City of Albuquerque Stormwater Construction Site Inspection Report

ESC File No.	K10E023J	Project Name:	WAQ1		
NPDES Id. No.	NMR1003DQ	Location:	7300 Meridian Pl. NW		
4/30/2021	Owner	Contractor			
Operator	Brunacini Development Ltd.				
Contact name & title	Angelo Brunacini				
e-mail	abrunacini@brunacini.com				
Contact Phone #	505-833-2928				
COA Inspector	Thomas Evans		Start/End Time:	11:25 AM/11:40 AM	
Construction Phase:	Earthwork				
Type of Inspection:	Regular	Storm Event	Past Storm Event >0.25"	311/Complaint Follow Up	
Weather at time of inspection?	clear		Temperature: ~	67	
Estimated date of last storm 0.25" or greater	4/28/2021

GRADING & EROSION CONTROL
PLAN

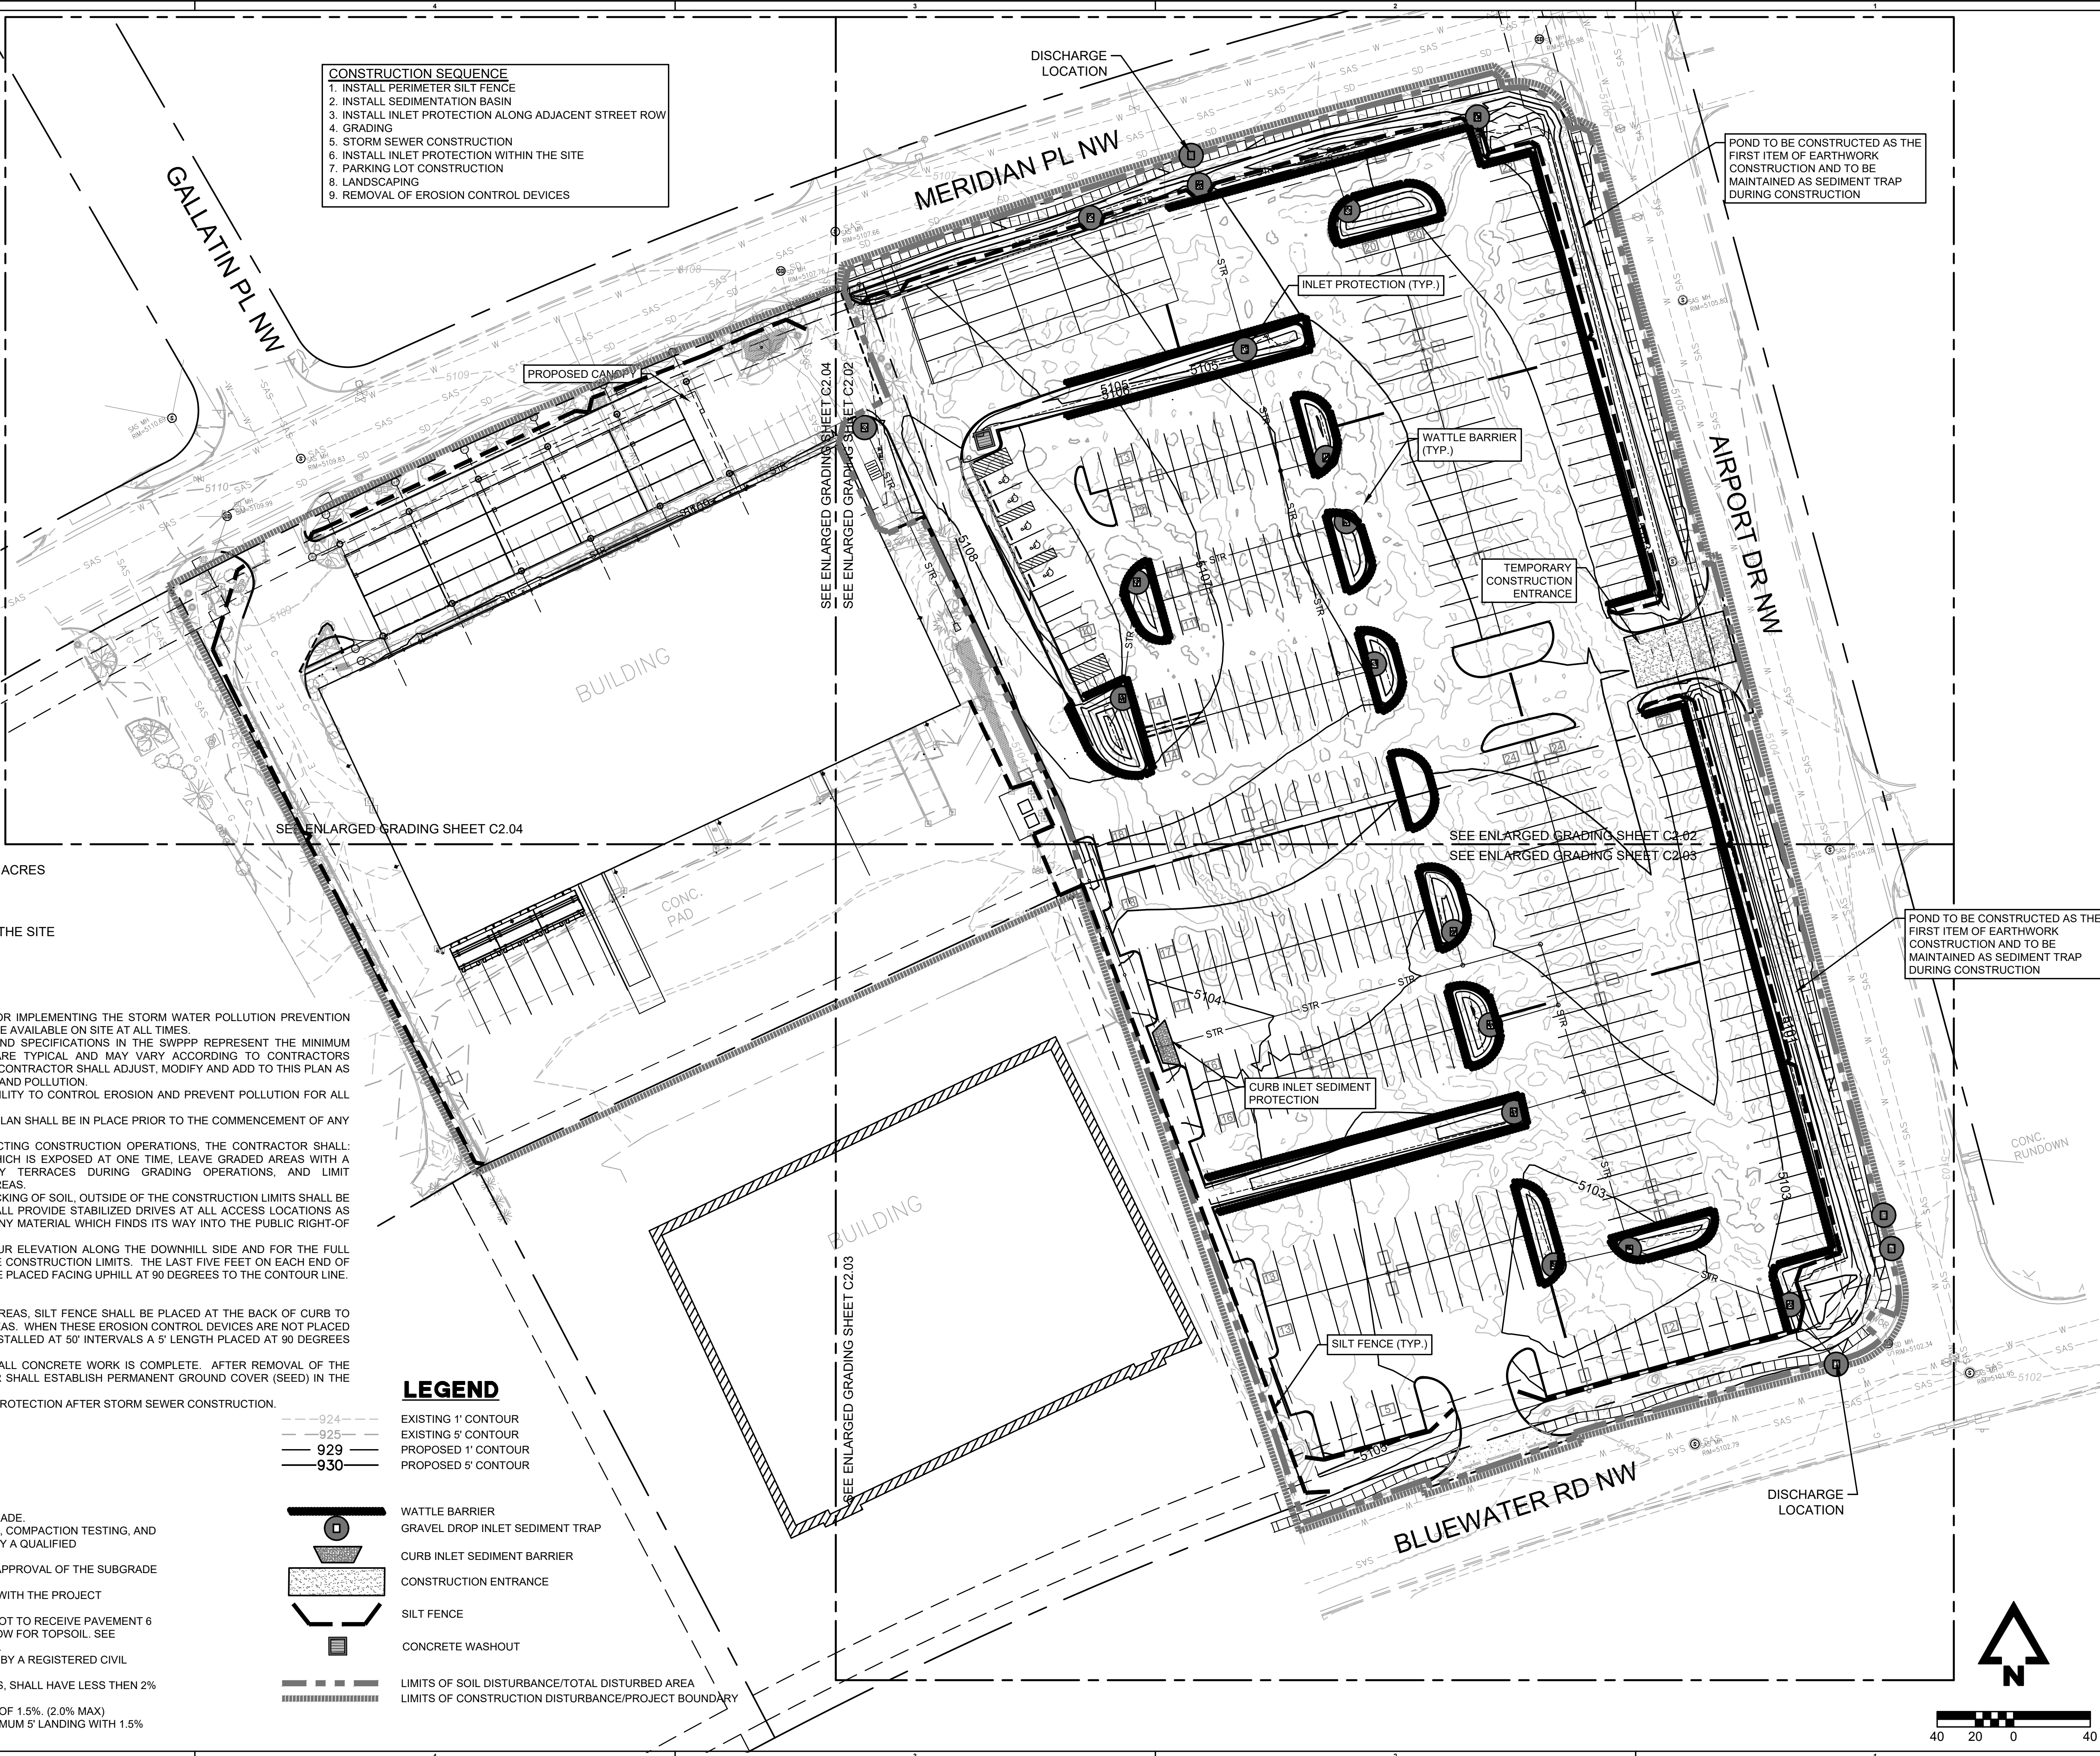
Item Number	Deficiency/ Corrective Action				
1	Trackout at the East entrance. Sweep trackout by the end of each business day.				
2	Sediment in streets and on sidewalks. Remove sediment by the end of each business day.				
3	Add NPDES Permit number to SWPPP posting				
4					
5
